April 1, 2016

**RE: Estates at Glendale Unit 2
Drainage Report and Grading and Drainage Plan
Engineer's Stamp Date 3-23-16 (File: B19D027)**

Rita Harmon, P.E.
Senior Engineer, Planning Dept.
Development Review Services

SECTION B-B  
NTS

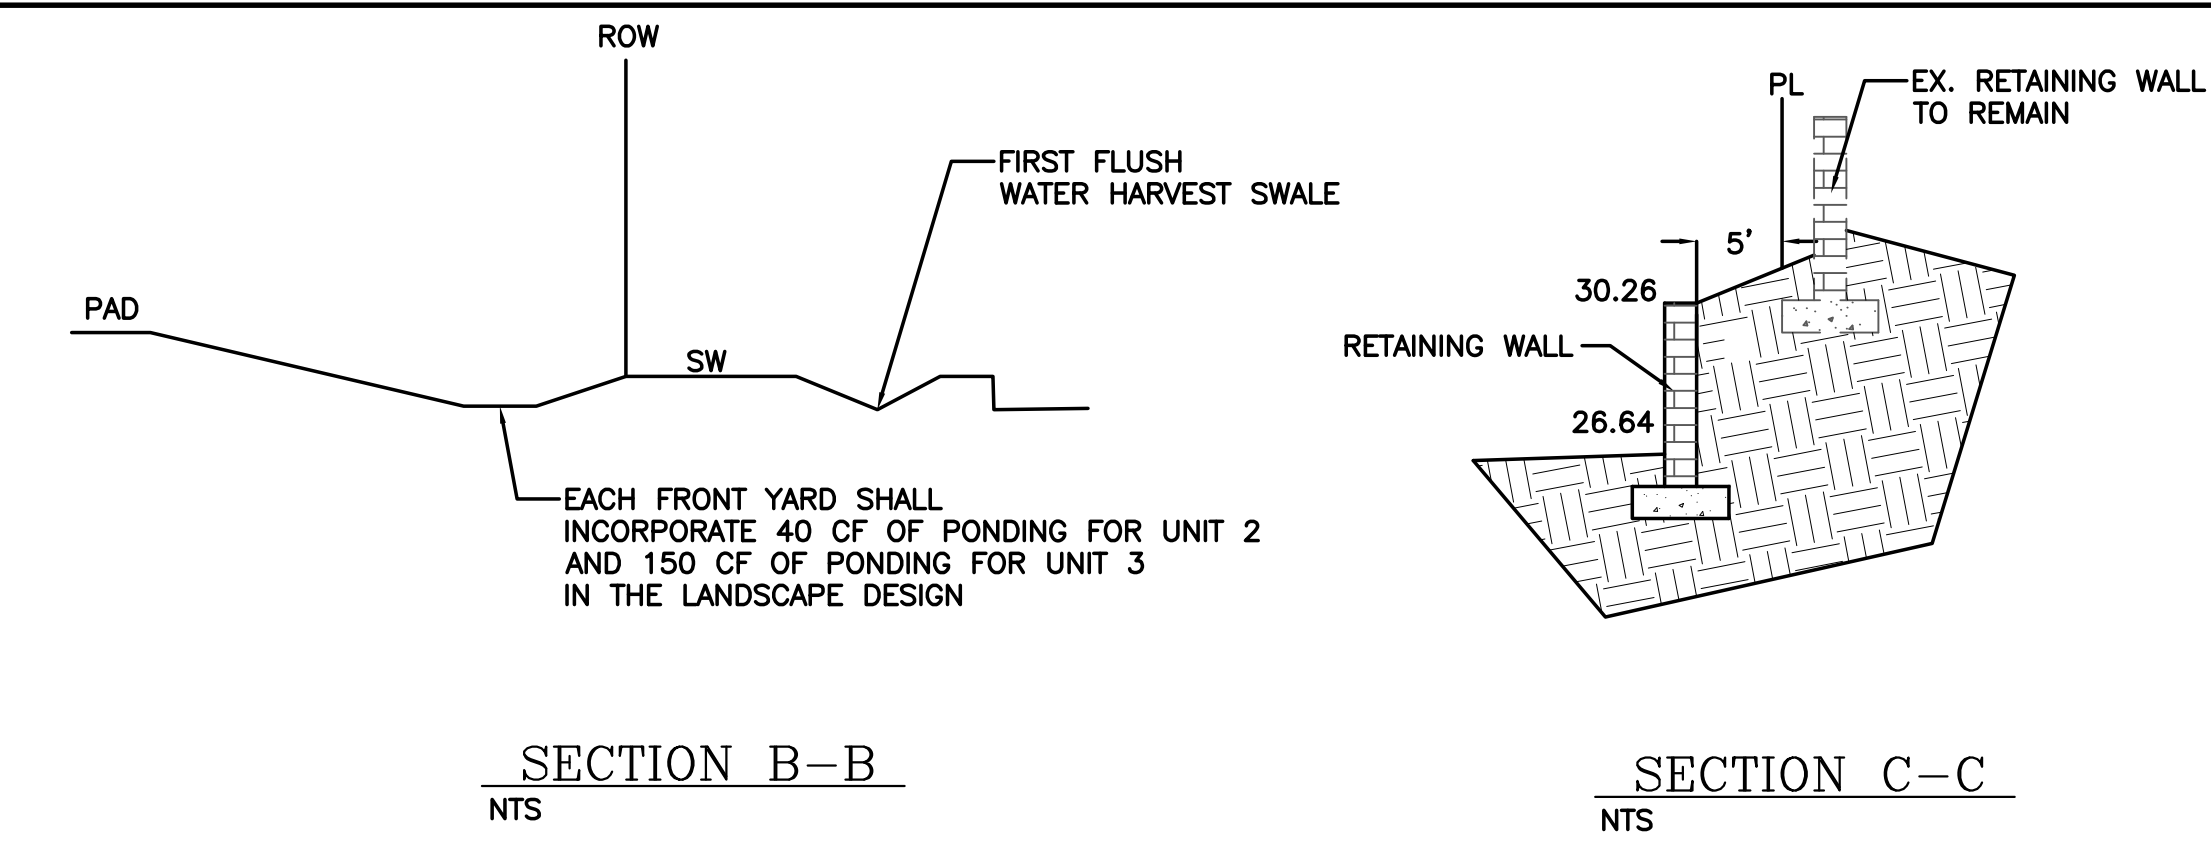
6. First Flush ponds are shown in Section B-B, however, show a depth. Also show in the plan view the approximate location and area of pond needed to capture 40cfs as stated in Section B-B. Show first flush calculation.

CONCRETE CHANNEL DETAIL  
NTS

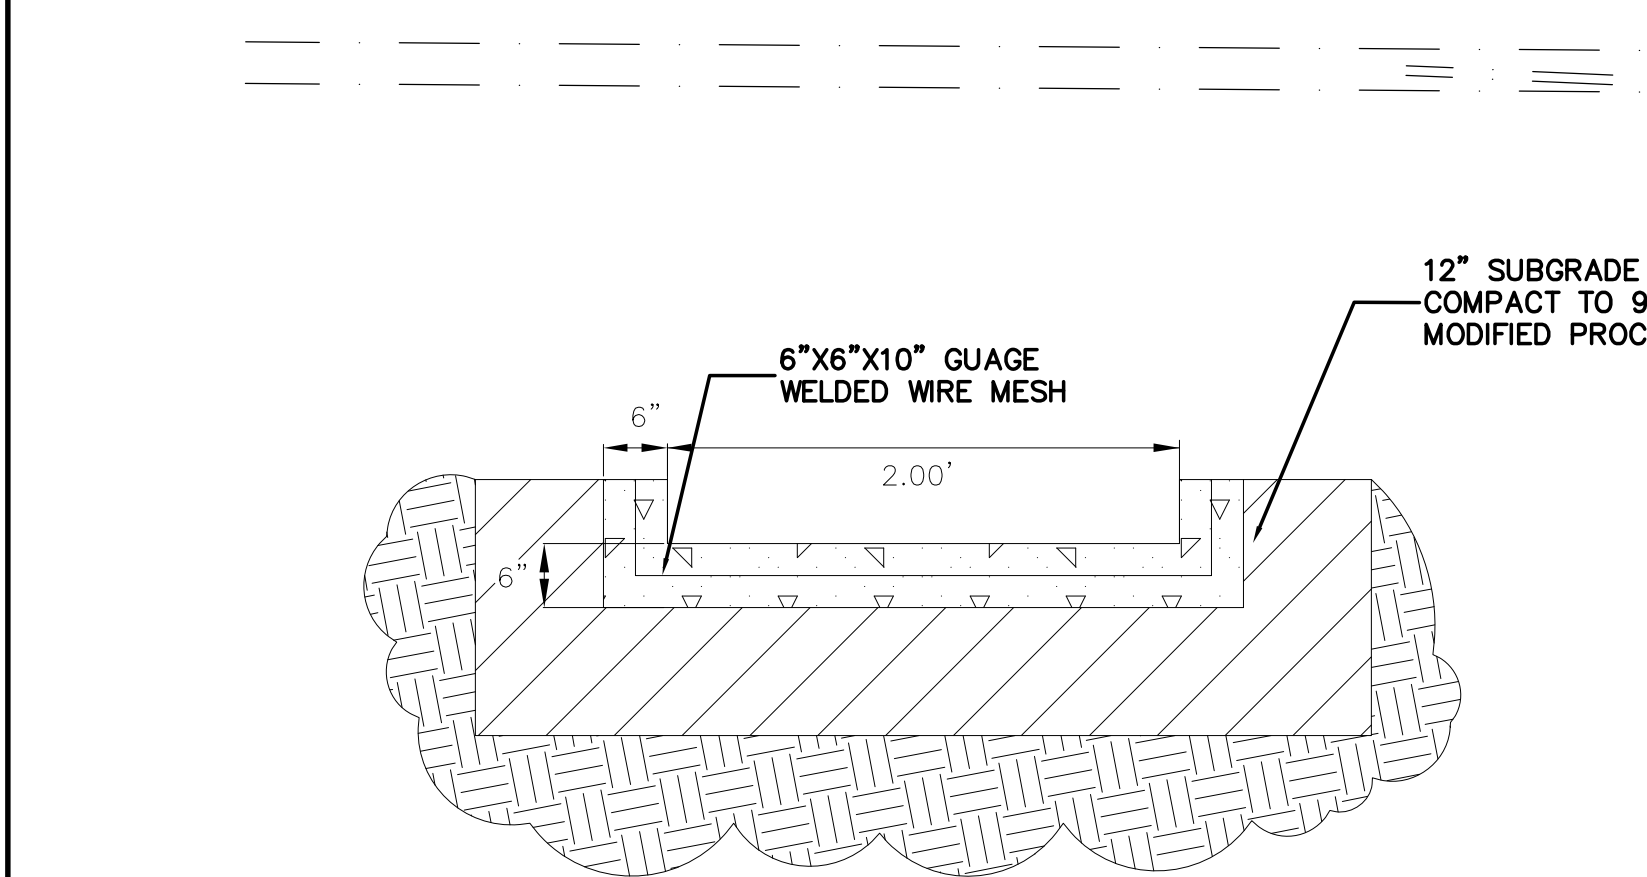
13. Detail and dimension channel that will allow the 1.31 cfs from offsite flows along with the 4.49 cfs to flow to the SW culvert at the end of the cul-de-sac.
